Statement of Response to An Bord Pleanála Opinion

Proposed Strategic Housing Development (SHD) at Ratoath, Co. Meath

On behalf of **BEO PROPERTIES LTD.**

May 2022

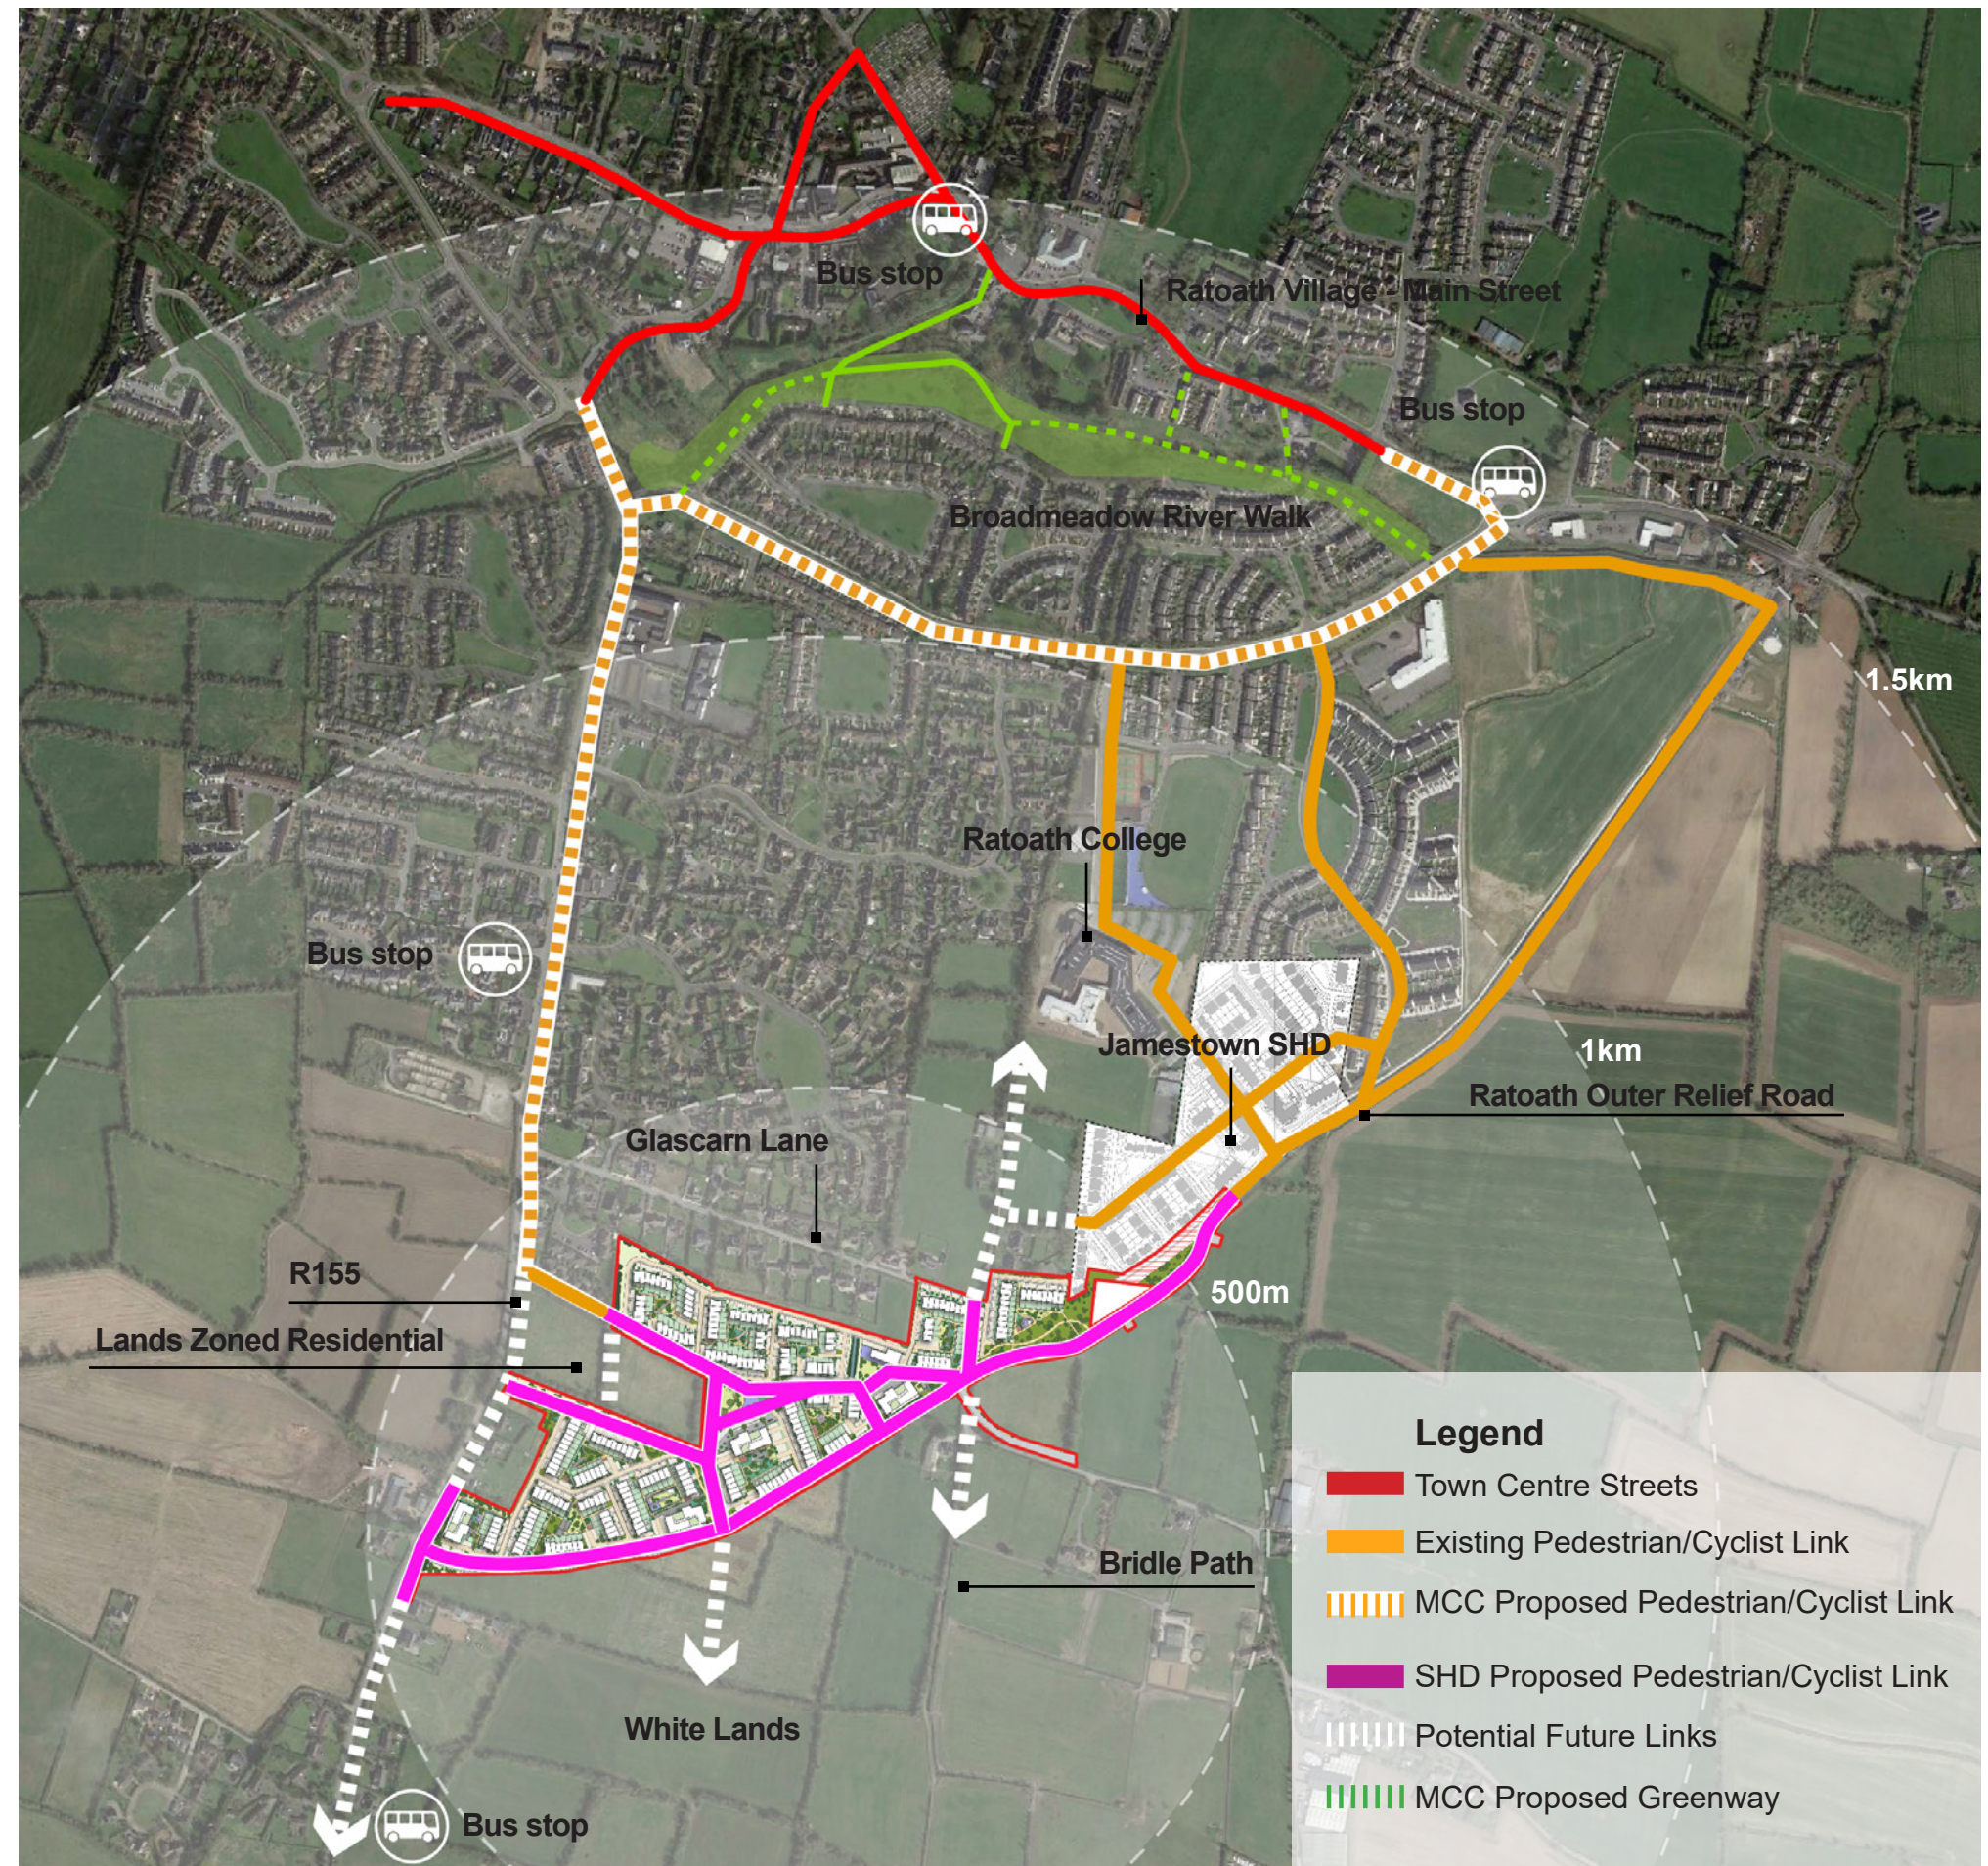
Further consideration and/or justification of the documents as they relate to the movement of pedestrians and cyclists from the subject site into Rathoath Village and surrounding area. The submitted documentation should demonstrate clear pedestrian and cycle connectivity and the timescale, phasing and delivery of any infrastructure associated with the proposed pedestrian and cycle connectivity, including any third-party consents required for the works. For the cycle facilities that are proposed, the specific compliance with the particular requirements of the National Cycle Manual should be demonstrated by the documents.

Response: The Board requested that the submitted documentation should demonstrate clear pedestrian and cycle connectivity and timescale phasing and delivery of any infrastructure associated with the proposed pedestrian and cycle connectivity.

The proposed development provides for a high level of permeability and connectivity throughout. An in-depth analysis of cyclist and pedestrian permeability and connectivity has been provided by RKD within their *Architectural and Urban Design Report* which is enclosed as part of this planning application. As shown on Figure 2-1 below the cycle network is developed based on the requirements of the National Cycle Manual including a central 3m wide cycleway and pedestrian path through the site that is off-road and remote from vehicular traffic. This central route offers high comfort levels and serves both commuter and leisure functions by connecting to the R155, Glascarn Lane and the RORR to access town.

With regard to the timeframe for the phasing and delivery of pedestrian and cyclist infrastructure associated with the proposed development, the first phase of the development will deliver three new cycle entrance points to the site and three pedestrian entrances with connections to both R155 and the RORR. This will allow cyclist and pedestrian connection to Jamestown SHD and Ratoath College from day one and tie in with MCC's proposed extension to the pedestrian and bicycle infrastructure of Ratoath Village.

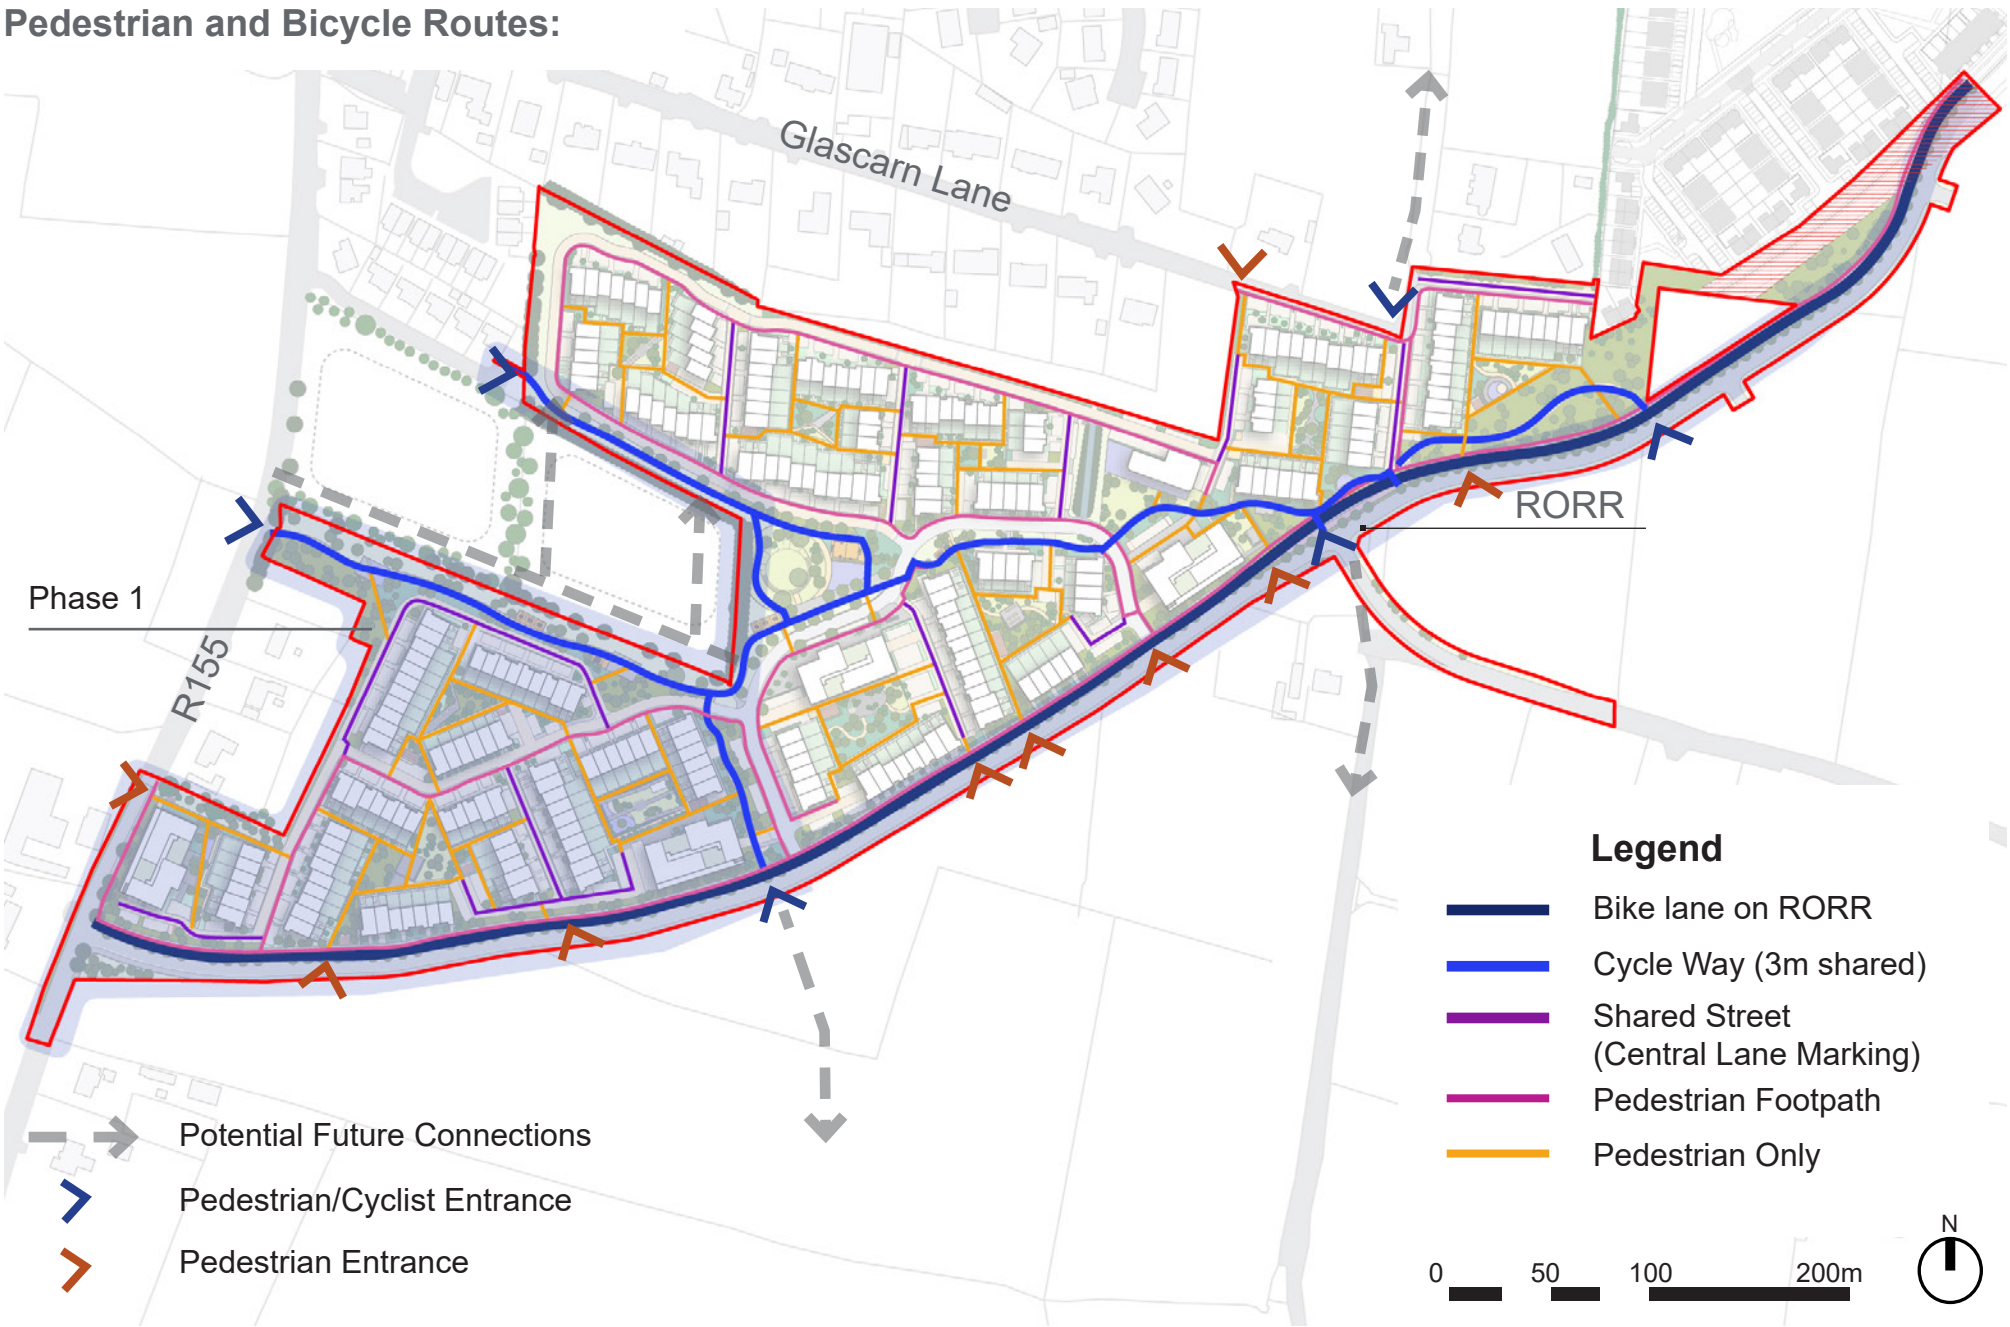
Furthermore, the Board requests that "For the cycle facilities that are proposed, the specific compliance with the particular requirements of the National Cycle Manual should be demonstrated by the documents". The design is compliant with the National Cycle Manual and all details can be found within the documentation submitted by RKD and O'Connor Sutton Cronin Consultant Engineers (OCSC). A key objective within this cycle manual is to "Provide for two abreast where possible for safety, visibility and attractiveness ". The proposed development provides three types of bicycle routes within the development, all providing for two abreast cycling as noted below,

- Greenway Spine: 3m wide Cycle Way shared with pedestrians
- RORR: 3m wide bike path next to 2.5m footpath separated from vehicles with 1.5m hard margin
- Shared Streets: 5.5m wide road with lane separator and bicycle marking

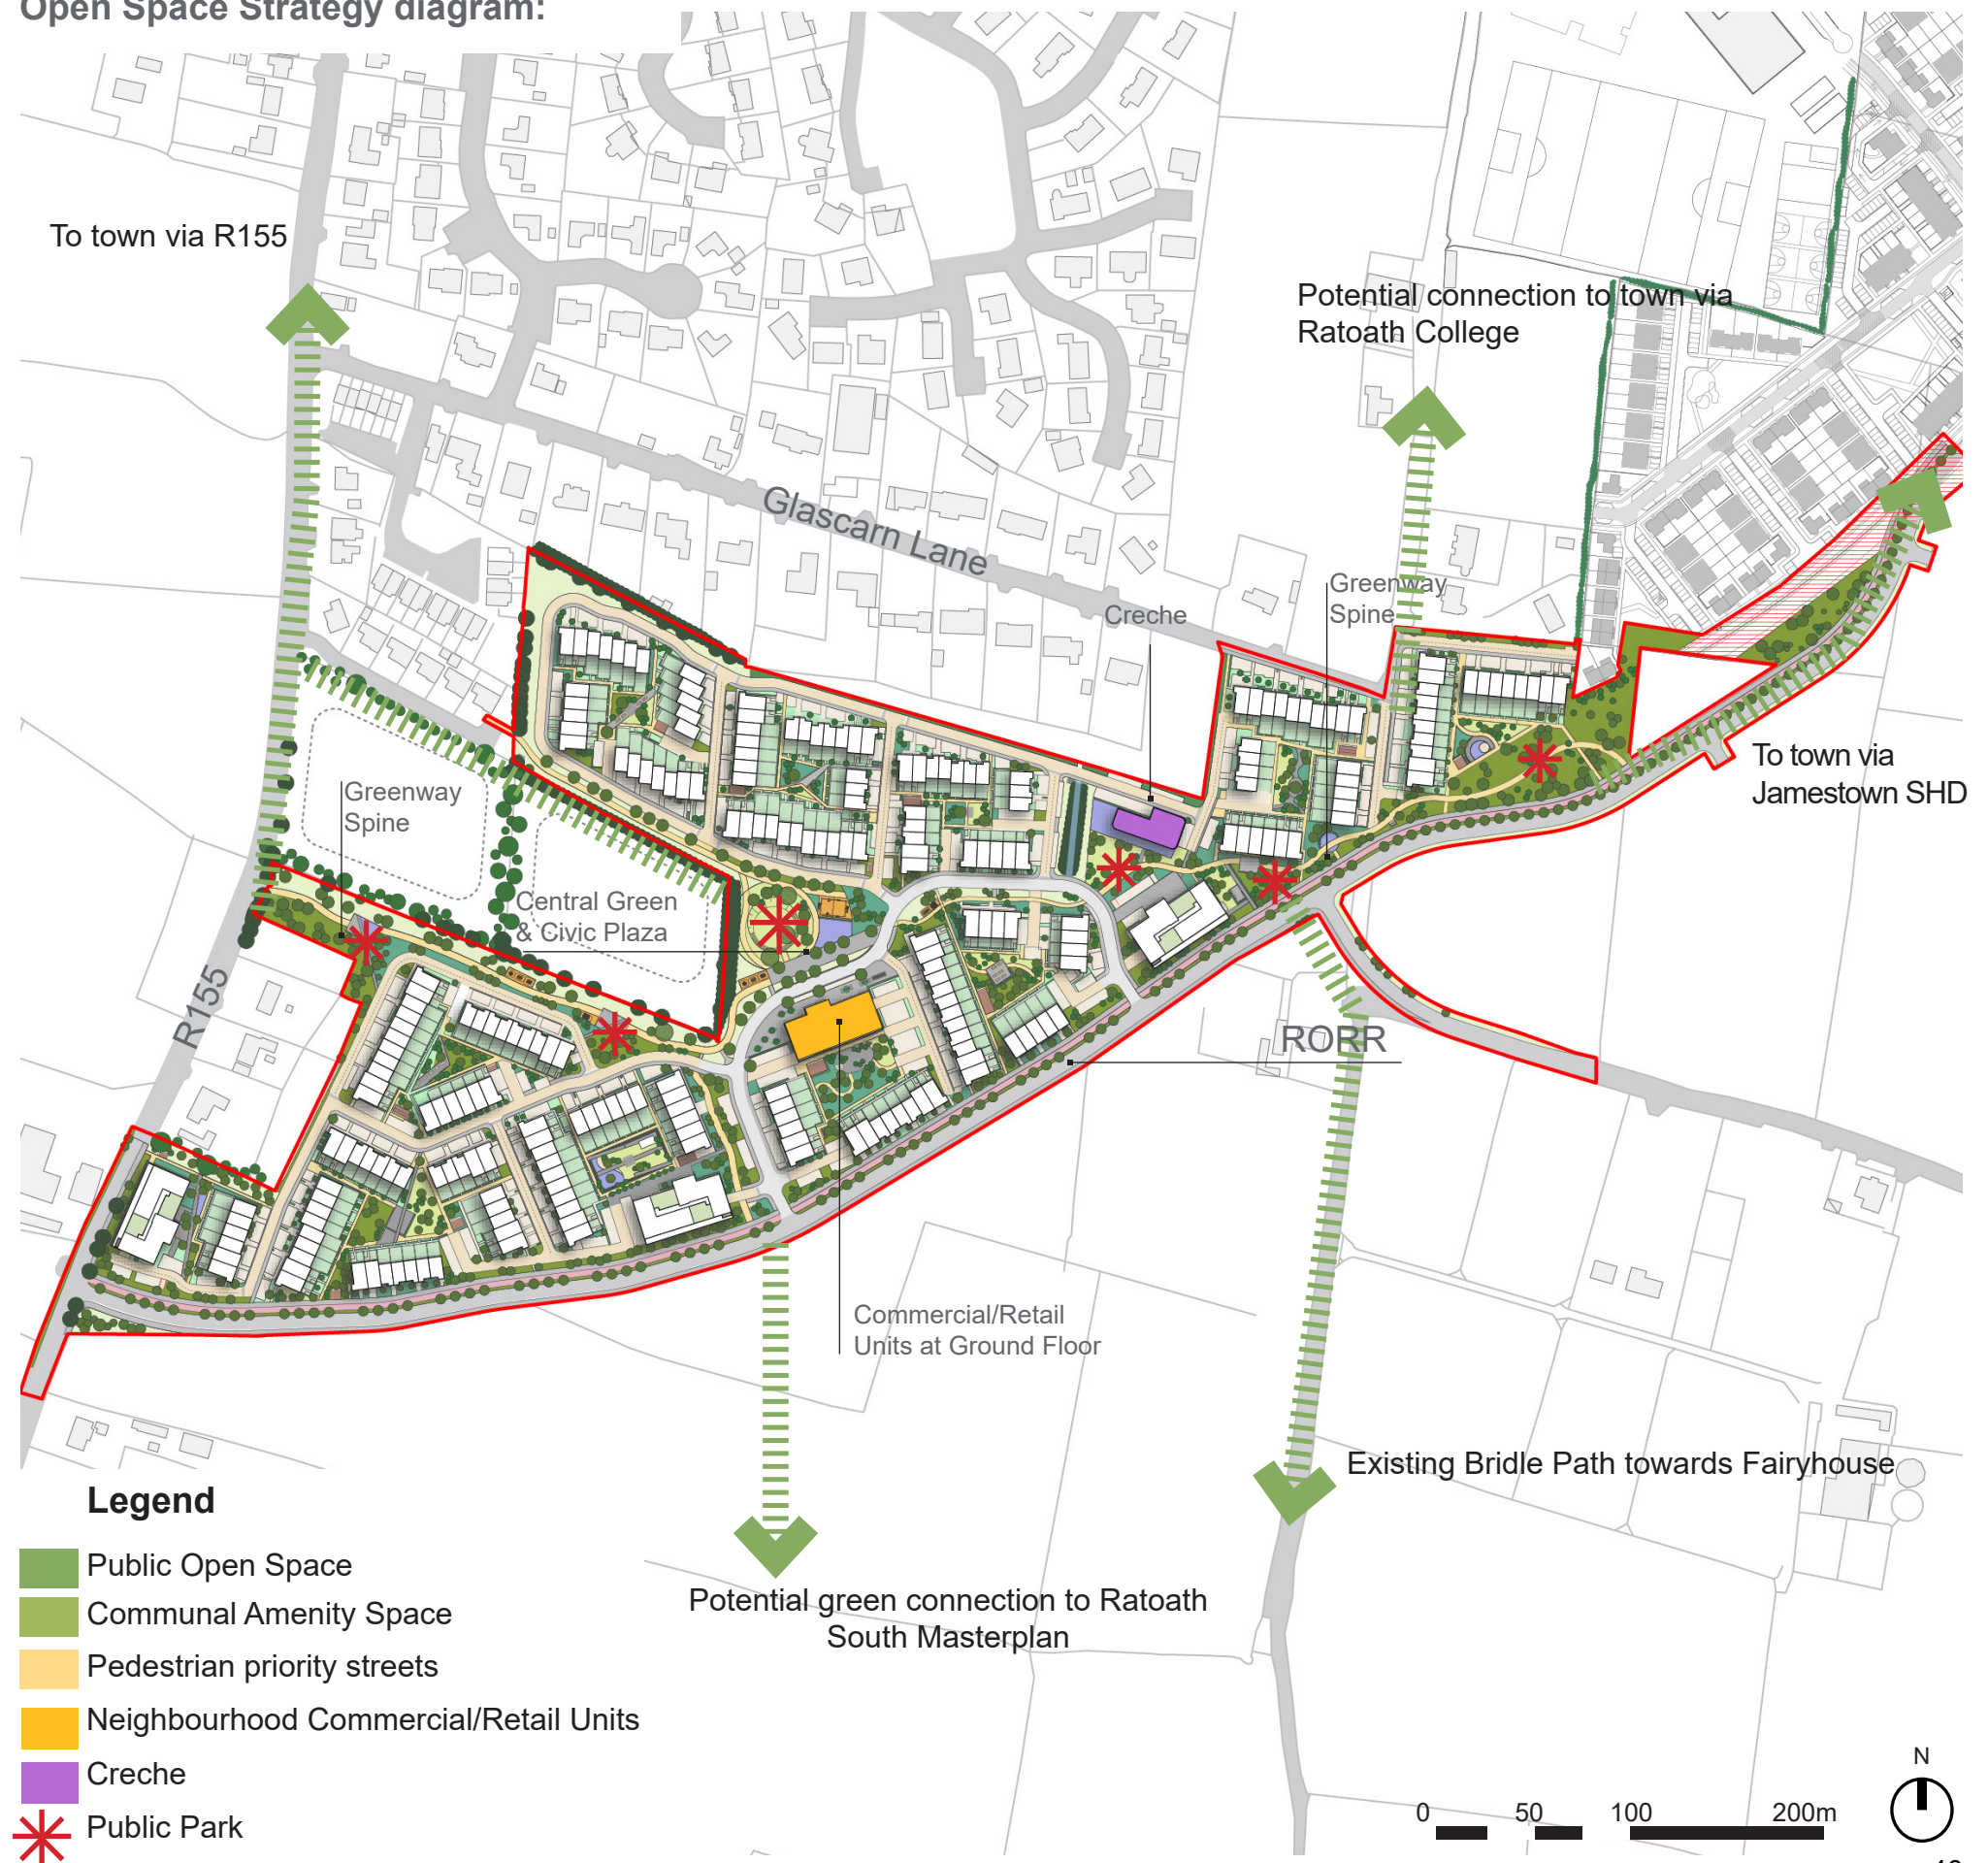
Additionally, the Board also requested that "further consideration/justification should address the open space strategy, inter alia the need passive surveillance and functionality of open space". With regard to the open space strategy the proposed design has positively addressed the management of these open spaces. A taking in charge map has been prepared by RKD with outlines the future management and maintenance of all public open space areas.

The proposed design provides for passive surveillance and the central courtyard provides a functional open space for all residents. As the communal open areas are not taken in charge a collective decision was taken by the design team to reduce rear boundary walls in order for these spaces to be taken in charge by future residents. It is envisaged that these low boundary walls will provide,
